State Environmental Policy Act MITIGATED DETERMINATION OF NONSIGNIFICANCE – ADDENDUM

- Description:** J.B. Mulcahy, Co-Director, Chimpanzee Sanctuary Northwest, plans to remove an existing driveway and build an approximately 800 foot driveway connecting parcels 666734 and 12628. This document is an addendum to an MDNS issued August 8th, 2016 in relation to Conditional Use Permit CU-15-00007, pursuant to Washington Administrative Code 197-11-625. The proposal has been amended to include the specific location of the planned driveway.
- Proponent:** Chimpanzee Sanctuary Northwest
- Location:** The project is located on two parcels approximately 4.5 miles southeast of Cle Elum in Section 11, T 19N, R16 E, WM in Kittitas County.
- Lead Agency:** Kittitas County

Pursuant to KCC Title 15 & WAC 197-11 the lead agency will not act on this proposal for 15 days. Any person, affected tribe, or agency may submit comments to the lead agency within 15 days of the date of issuance of the Addendum MDNS. The lead agency will then: retain, modify or withdraw the decision. The determination pertains to the original file SE-16-00002 and this Addendum file SE-18-00002.

# CRITICAL AREAS STUDY MAP

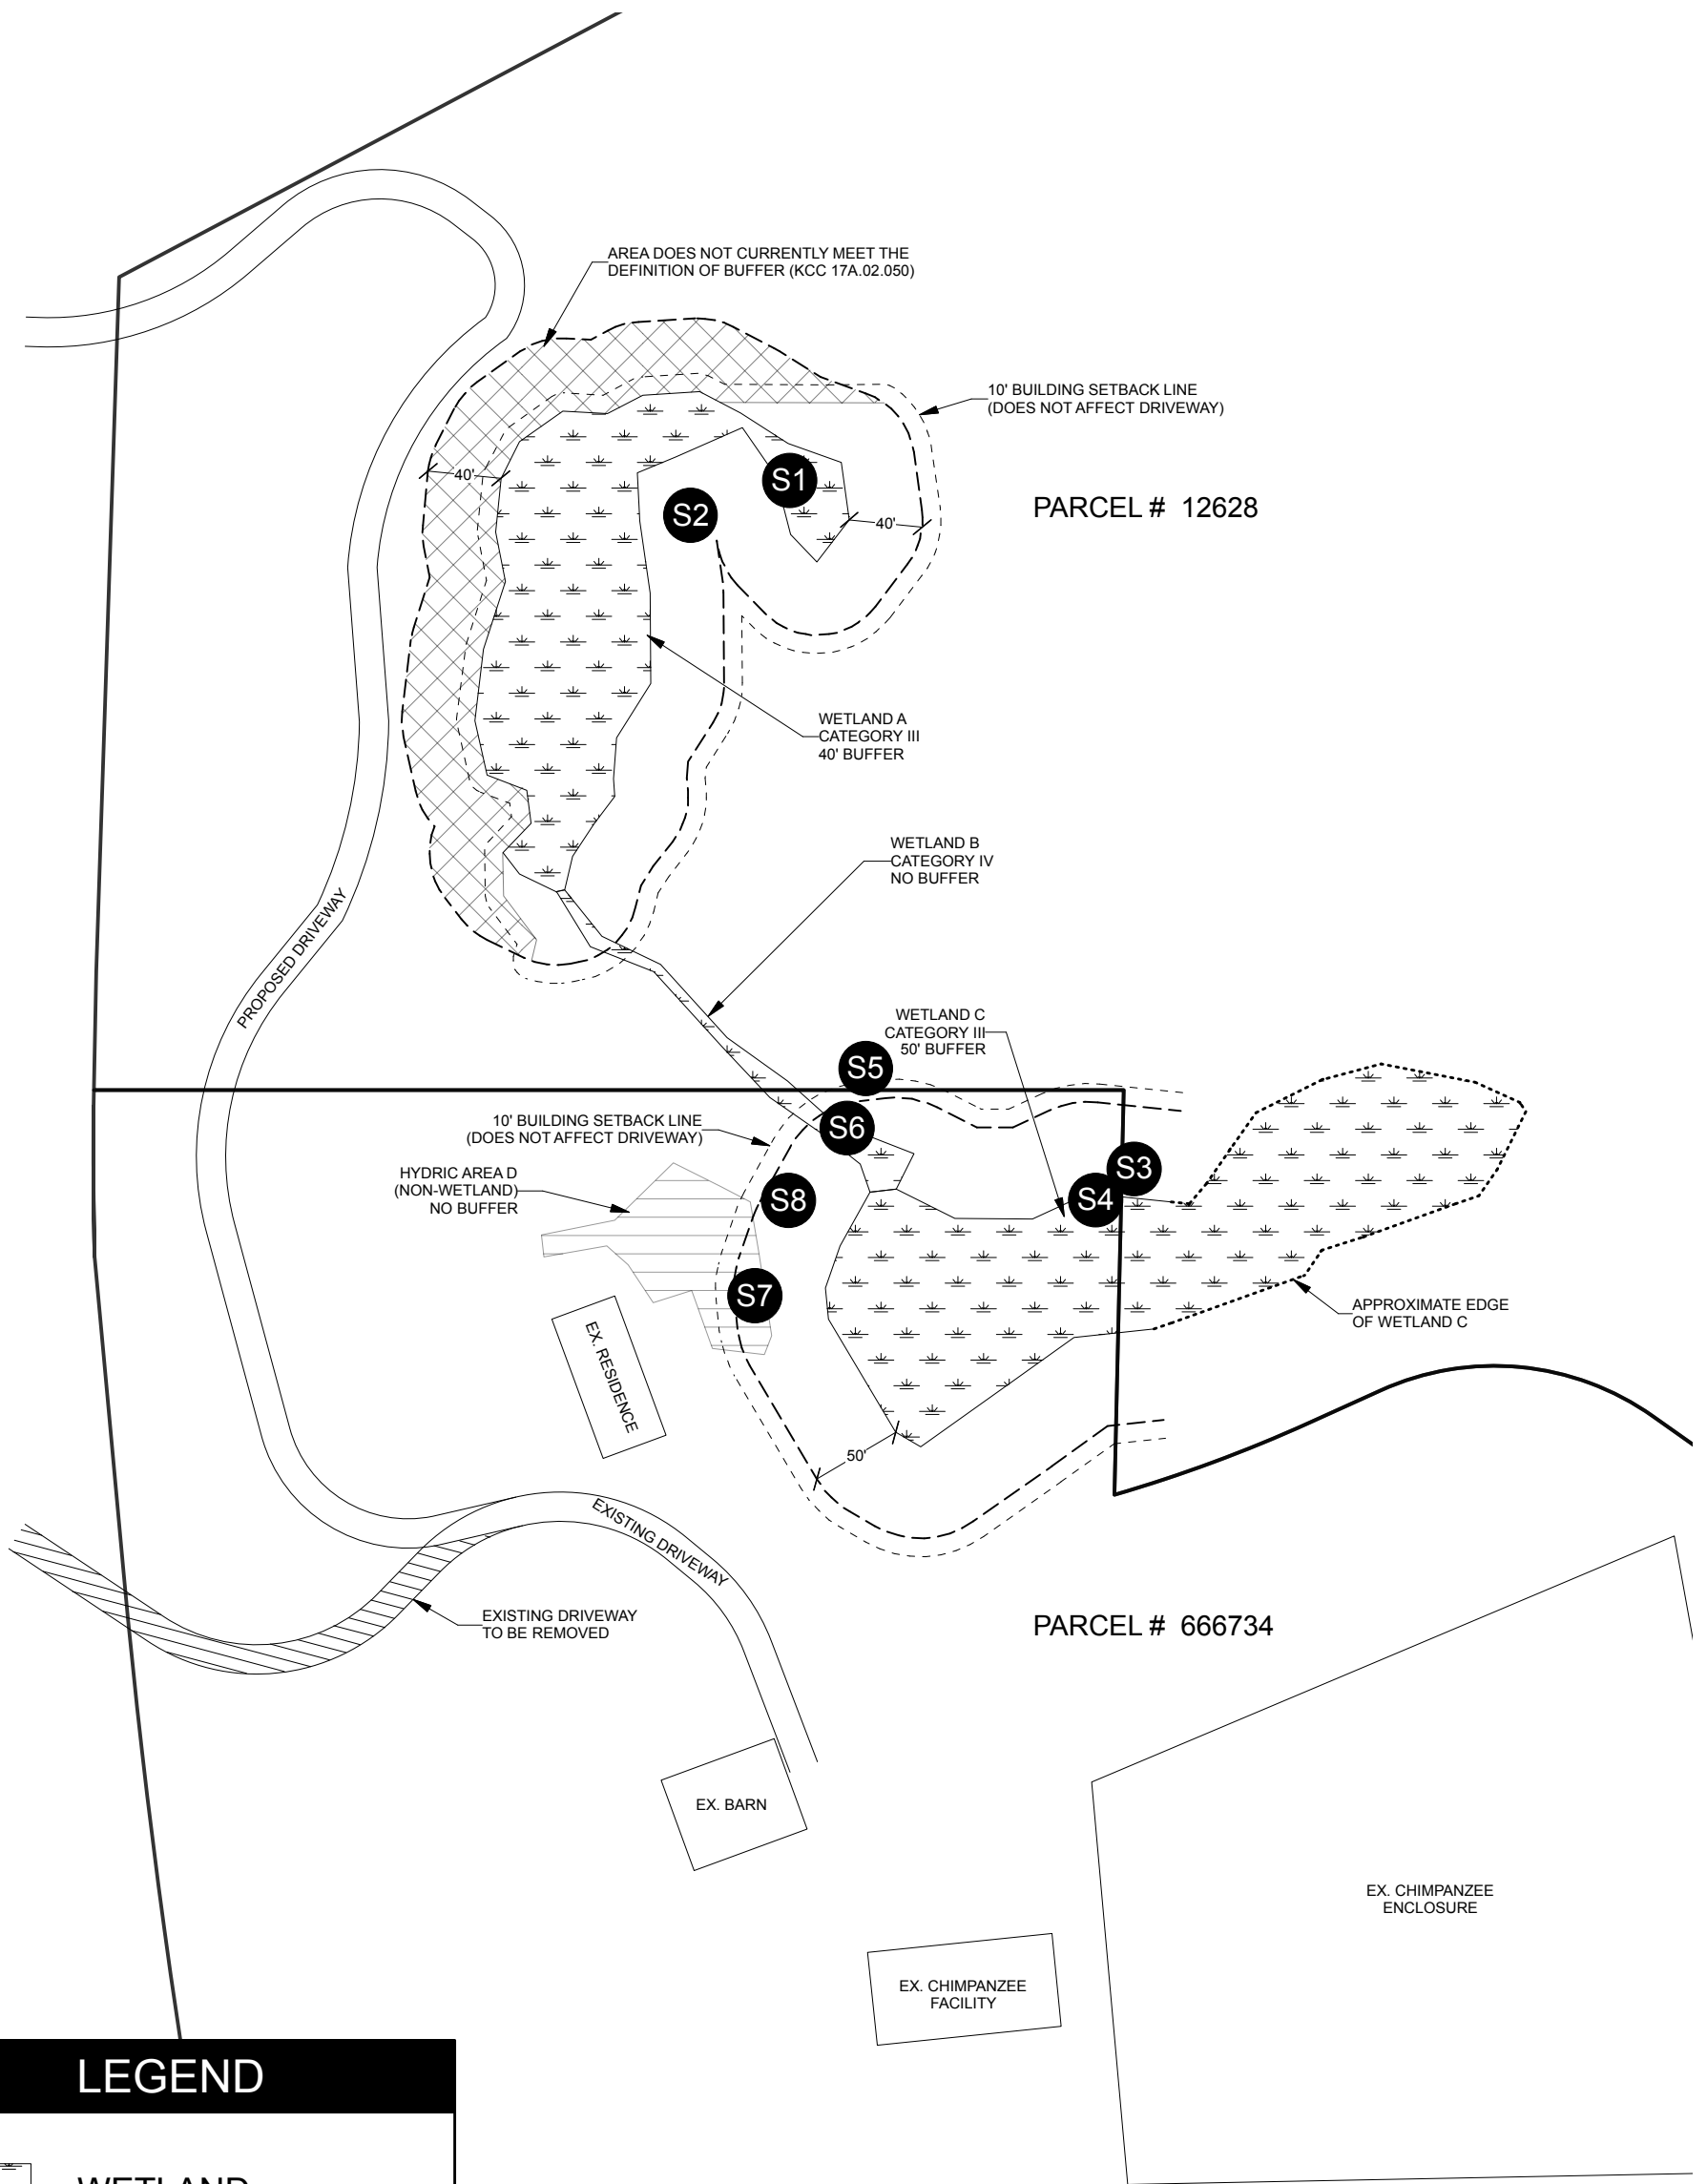
- ~~6) The Washington Department of Ecology also believes that wetlands on the property may extend further than is indicated Wetland Inventory Maps. The proposed new road approach may intersect wetland areas or buffers. Wetland reconnaissance required, and depending upon the outcome, wetland delineation or a wetland mitigation report will be required. The applicant can contact Catherine Reed at (509) 575-2616 for wetland assistance.~~

- 6) The proposed driveway has been routed to avoid vegetated buffers around existing wetlands, consistent with KCC 17A.04.020. The proposed driveway is routed outside the 40’ buffer around the Category III wetland to the north of the parcel # 12628, and is routed outside of the 50’ buffer around the Category III wetland to the south.
